PRE-DEVELOPMENT APPLICATION

13 July 2018

Pre-Development Application No:	PR2018/00051
Land:	Lot 1 DP 1236735
Property Address:	50(Future 36) Honeysuckle Drive Newcastle
Proposed Development:	Mixed use development

Floor Plan - Basement 02

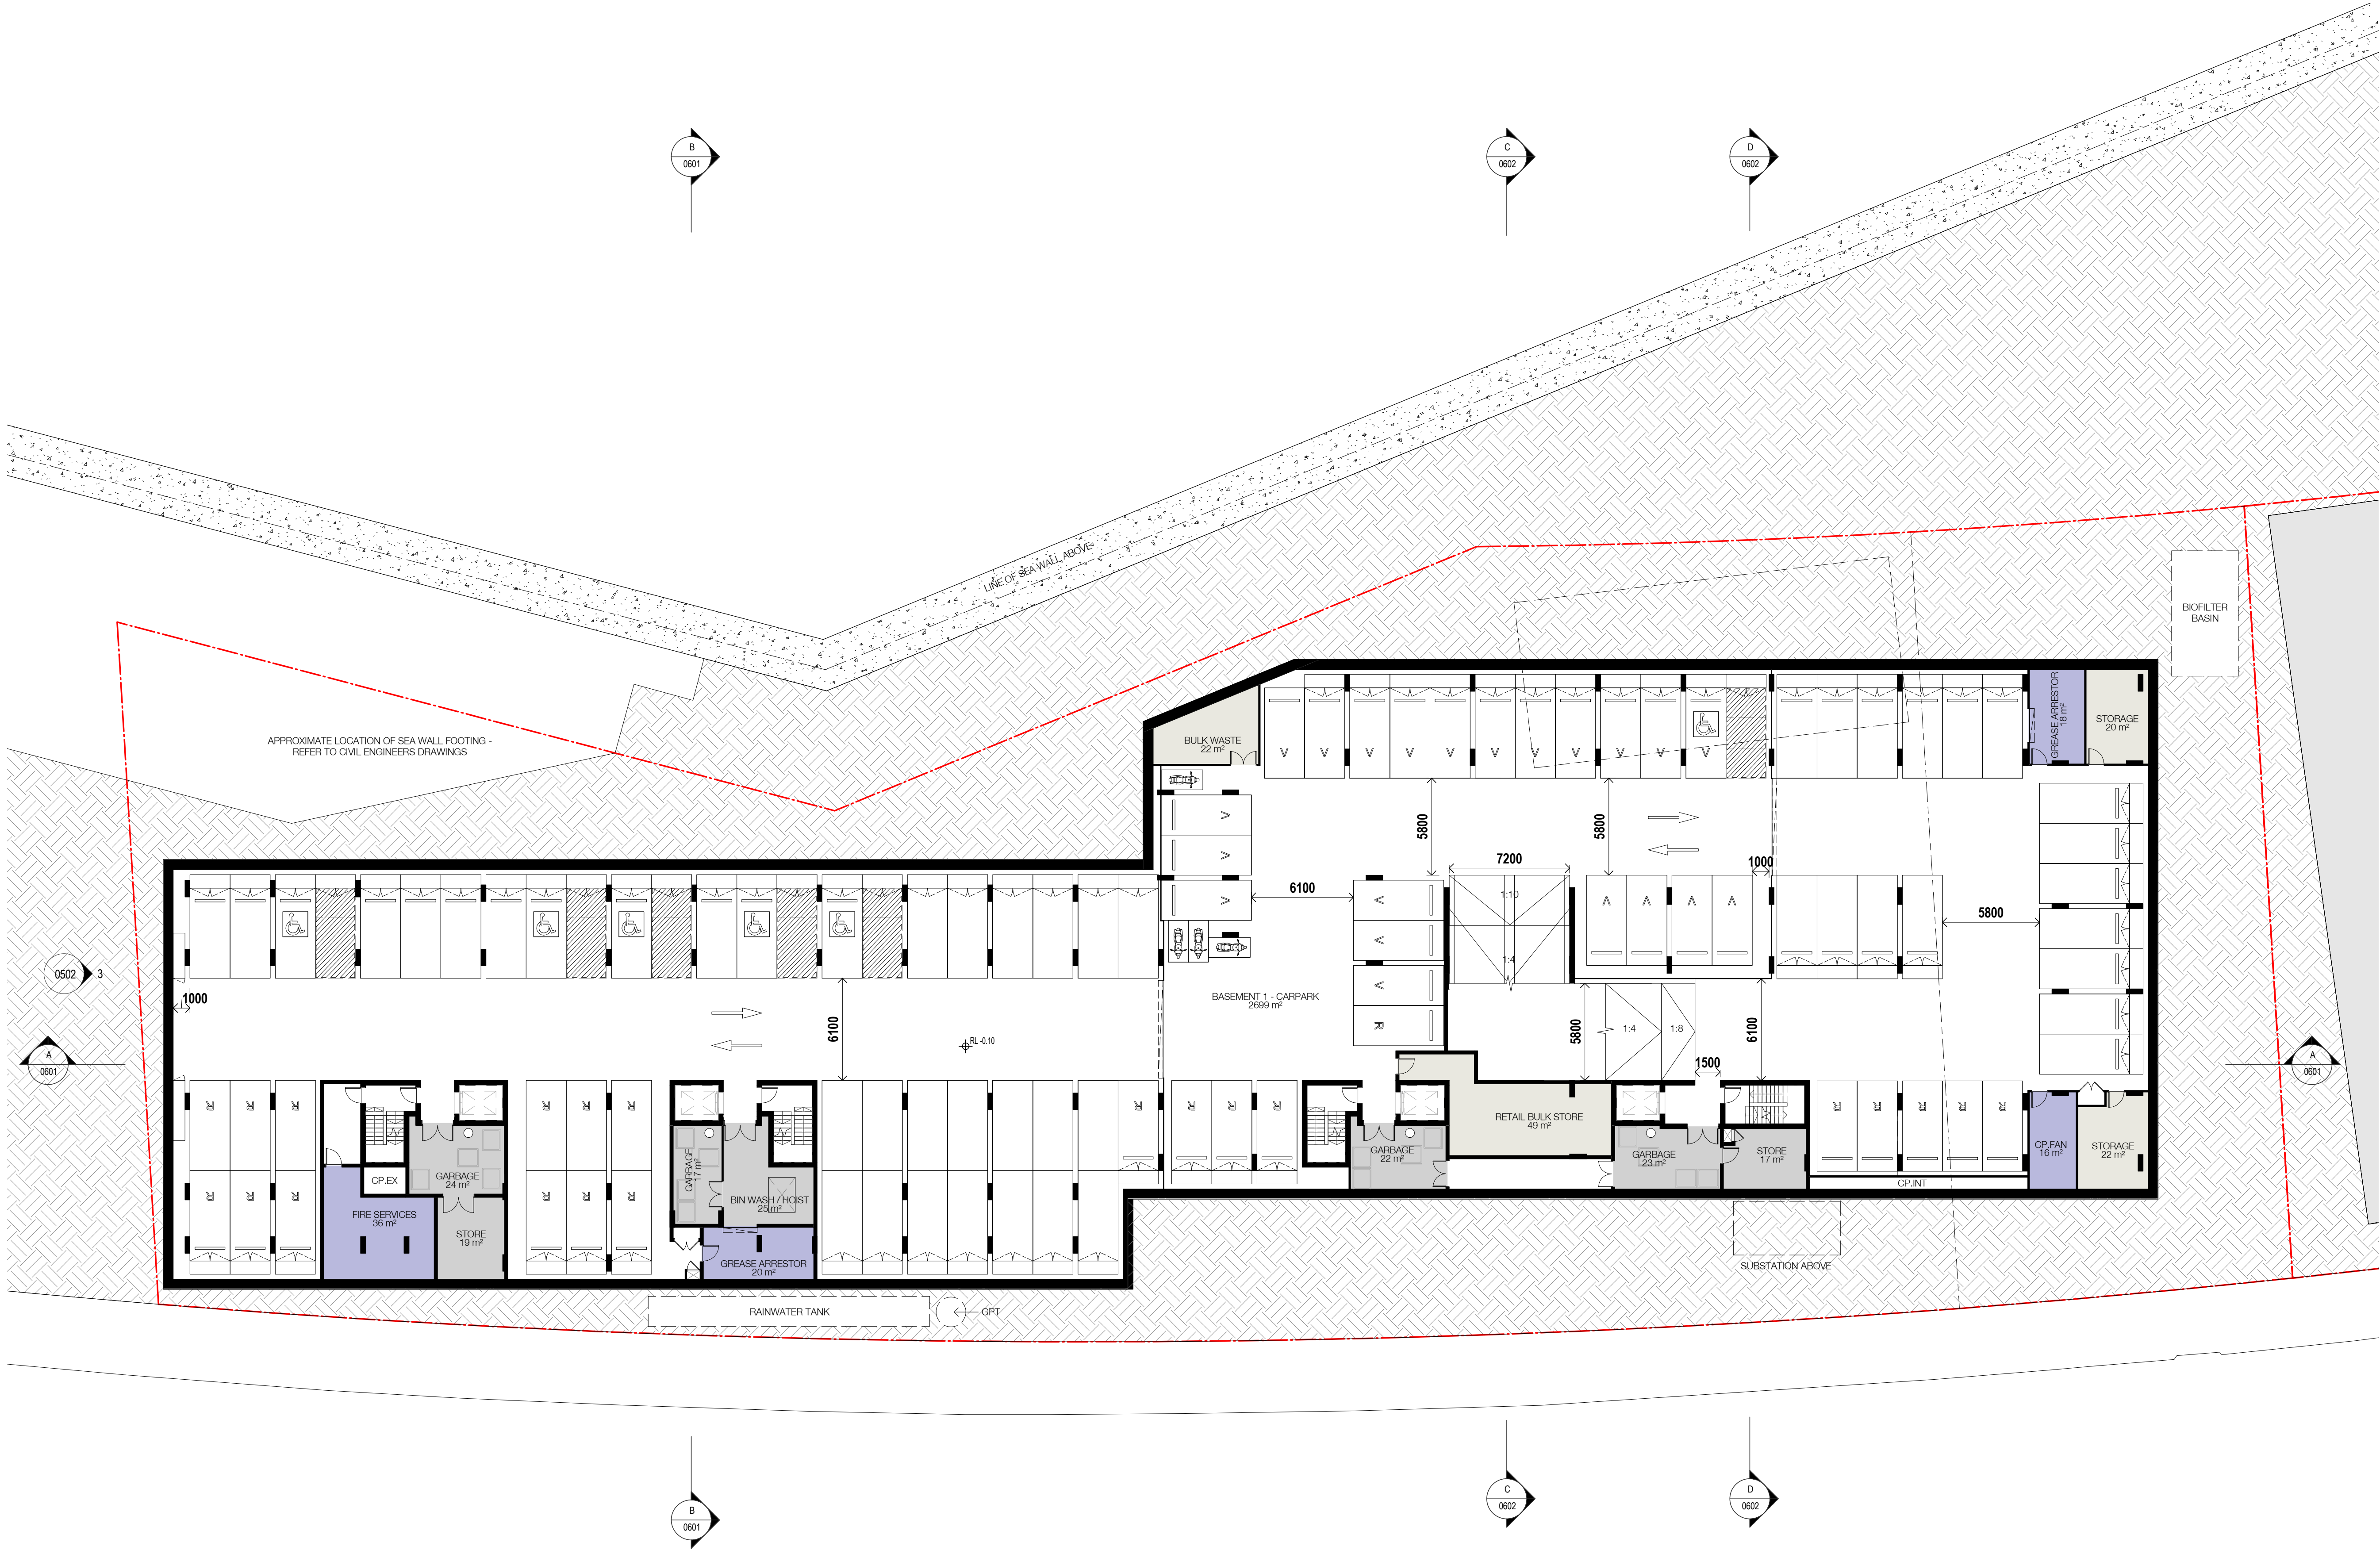
The submitted Basement 02 Floor plan Dwg. No. DA-A-0201 Rev 03 dated 06/06/2018 indicates that the following parking:-

- 79 residential spaces & 14 tandem spaces
- 5 adaptable spaces
- Total Spaces - 98

Overall, the proposal indicates 190 off-street parking spaces which exceed the parking rates of the Newcastle Development Control Plan 2012.

Based on the above, it is recommended that at a minimum of 1 parking space is allocated per dwelling. Additional parking can be provided to three bedroom dwellings and it is suggested that tandem parking may be more suited as it will be easier to manage.
